RE: Response to Submissions Tweed Sand Plant Expansion, Cudgen Tweed LGA (SSD 10398)

Attachment 1: Detailed BCD Comments – Response to Submissions for the proposed Tweed Sand Plant Expansion at Cudgen

TITLE
LAKE BANK PROFILE LAYOUT
 SCALE
 1:6000 AT A1
 1:12000 AT A3

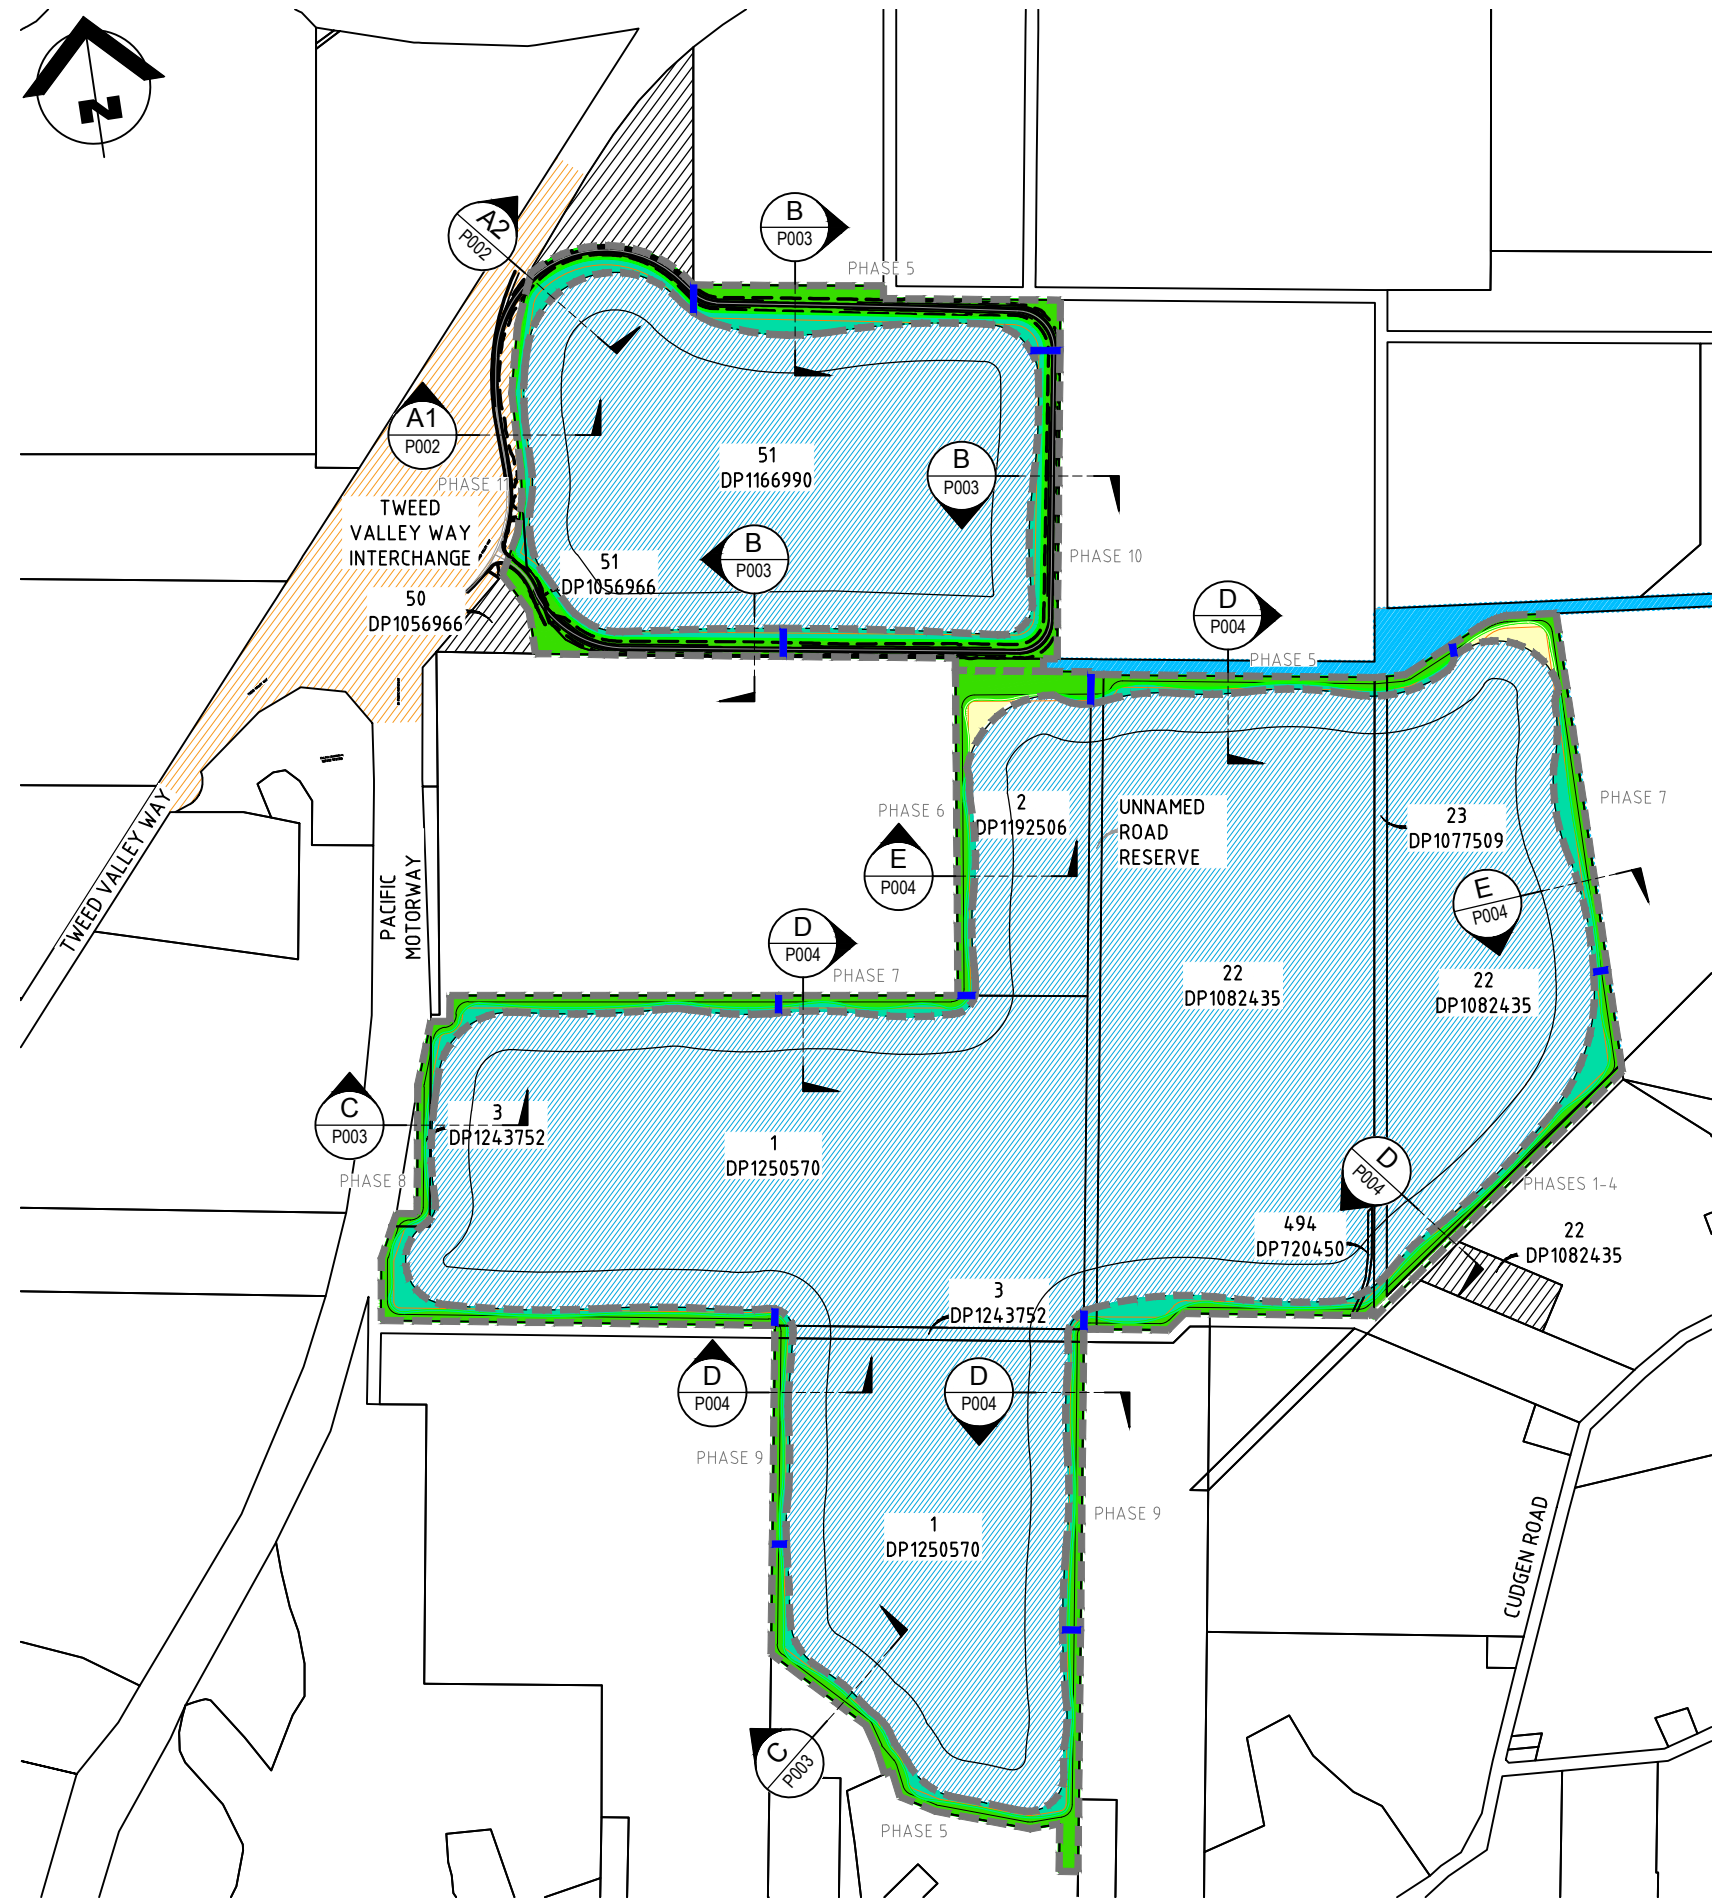
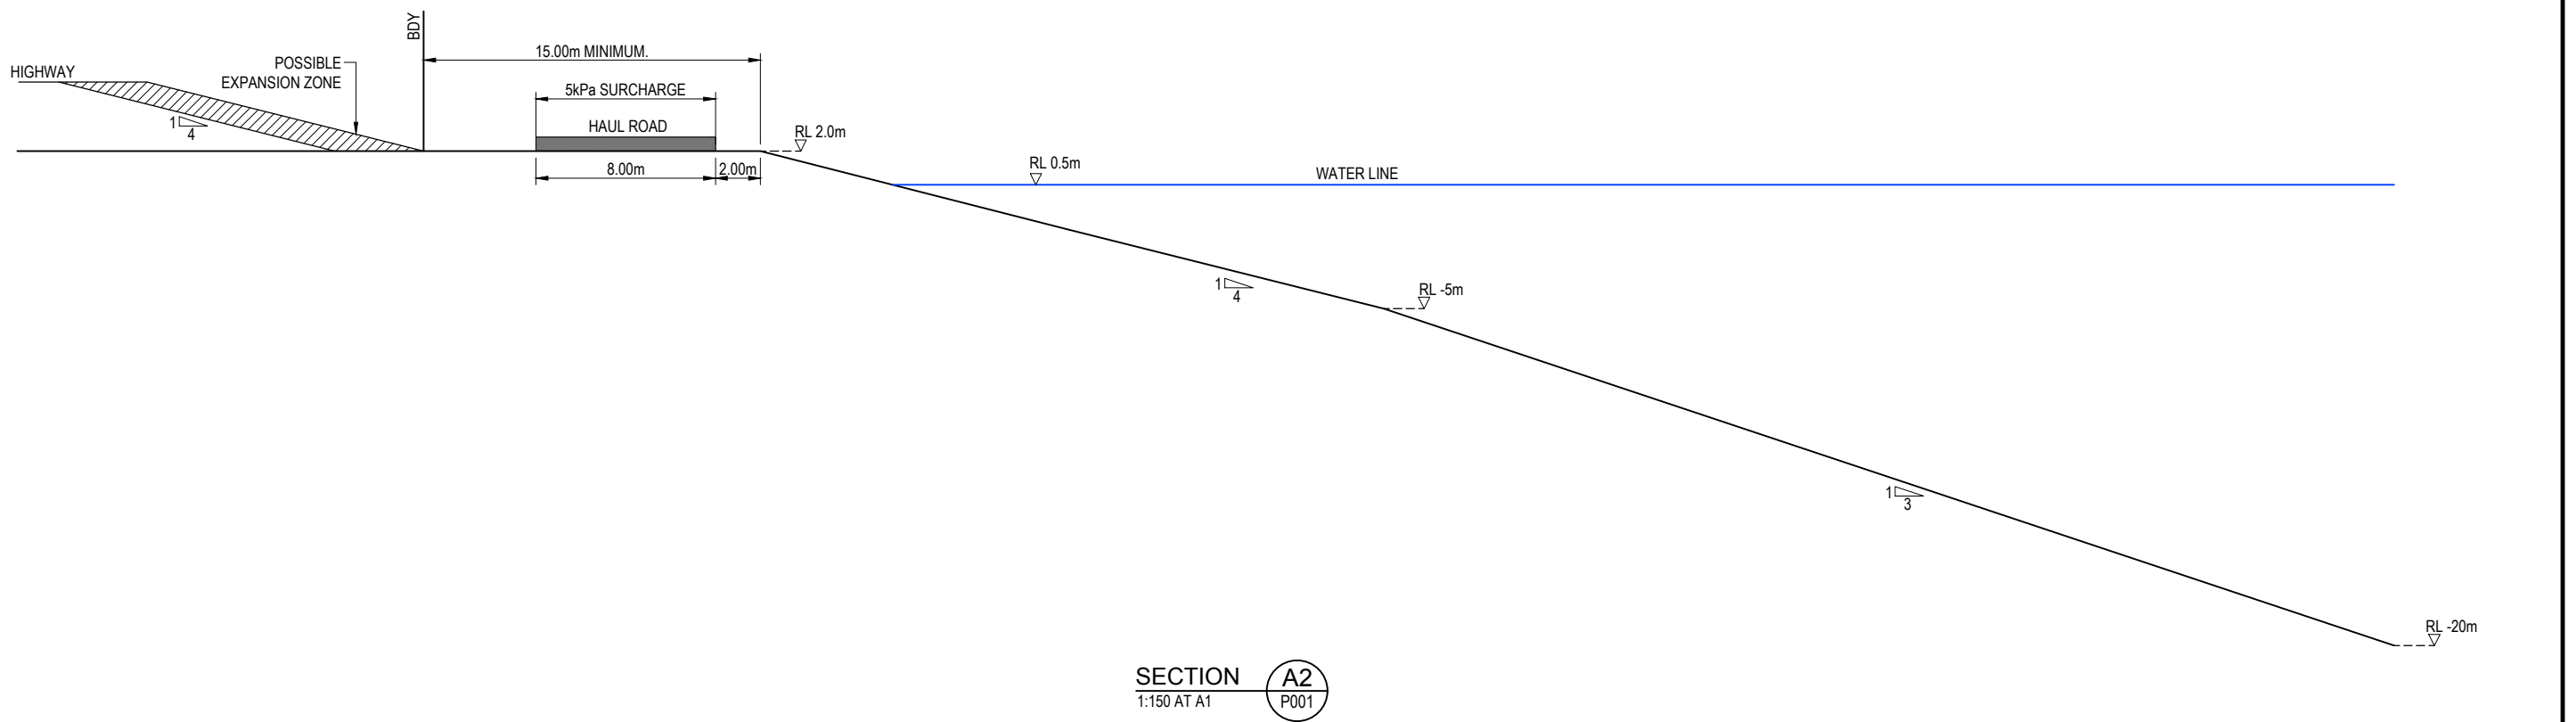
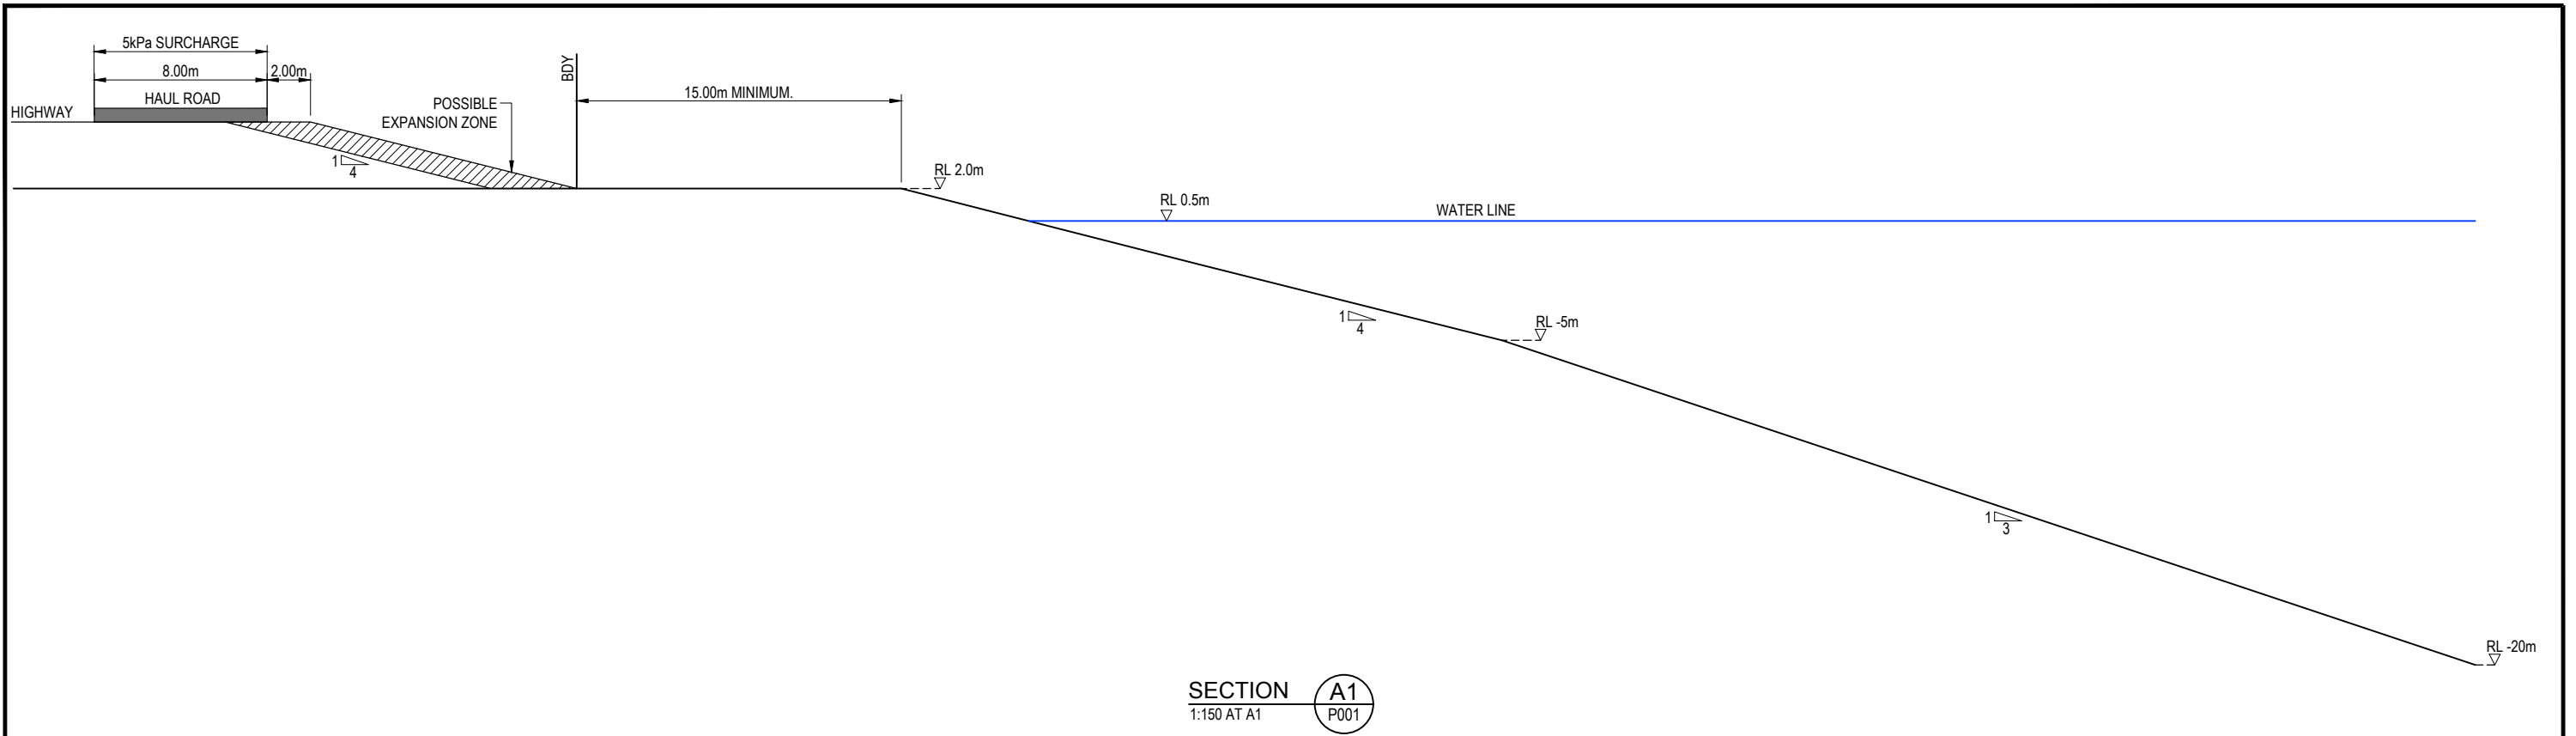
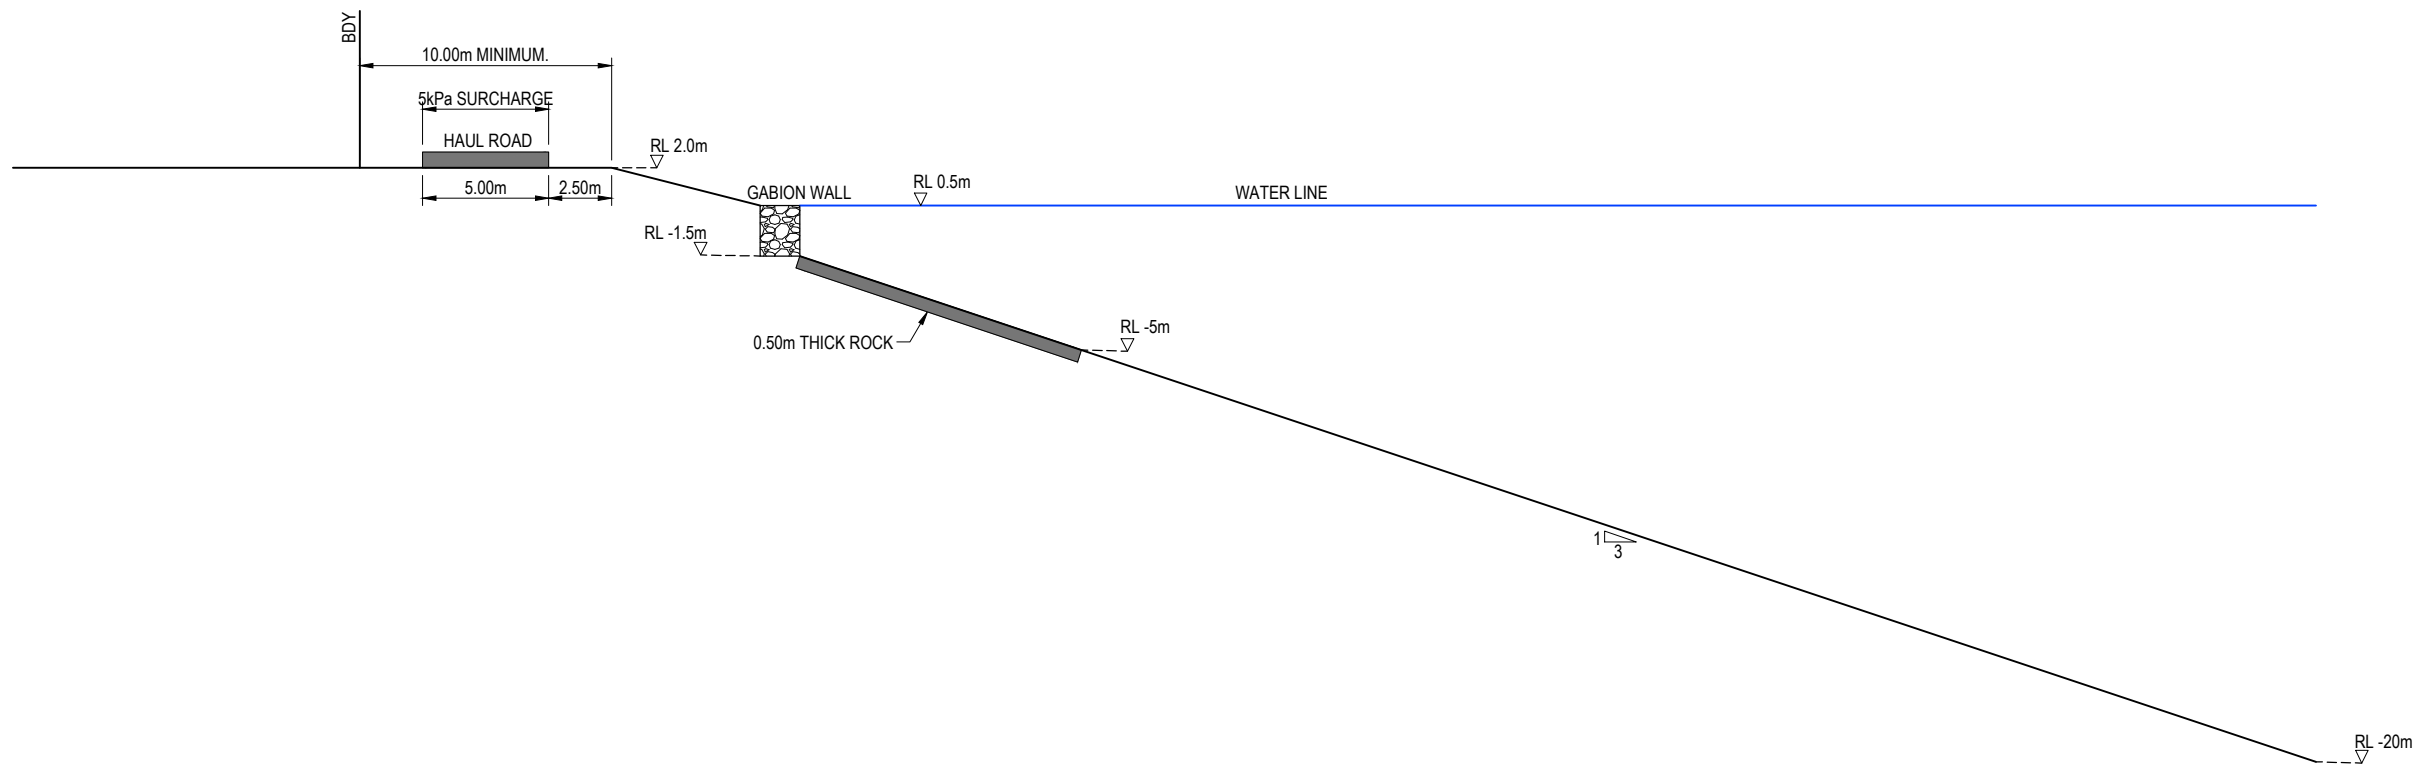
The BCD does not consider the rehabilitation arrangements as described in the Concept Rehabilitation and Landscape Management Plan (CRLMP) prepared by JWA dated November 2021 adequately meet the above Strategic Framework principles. The proposed rehabilitation involves small, linear strips of vegetation around open bodies of water. These strips will become increasingly waterlogged and degraded over time as described in the SRT (p2):

The proposed final phase of the project is for large open water bodies where the sand has been extracted with limited rehabilitation areas around the fringes of the water bodies. These areas will have limited biodiversity or recreational values. As noted above, the SRT states “if an appropriate alternative use cannot be found for the site” the land will be retained in private ownership (Hanson). Such areas would require ongoing management and monitoring to protect water quality and other environmental values. It is not clear how such management and monitoring would be funded by the company once it has completed its extraction operations at the site.

The final rehabilitation will result in large bodies of standing open water. No specific goals for the end-use water quality have been established as discussed in the Surface Water Assessment Appendix B to the EIS by Gilbert and Sutherland.

2. The rehabilitation plan should be amended to describe how the land will be restored to viable, self-sustaining ecosystems that will provide diverse and flourishing habitats for native species and should also demonstrate clear measurable targets, timeframes, responsibilities, monitoring and performance criteria for these works that will enable future oversight.
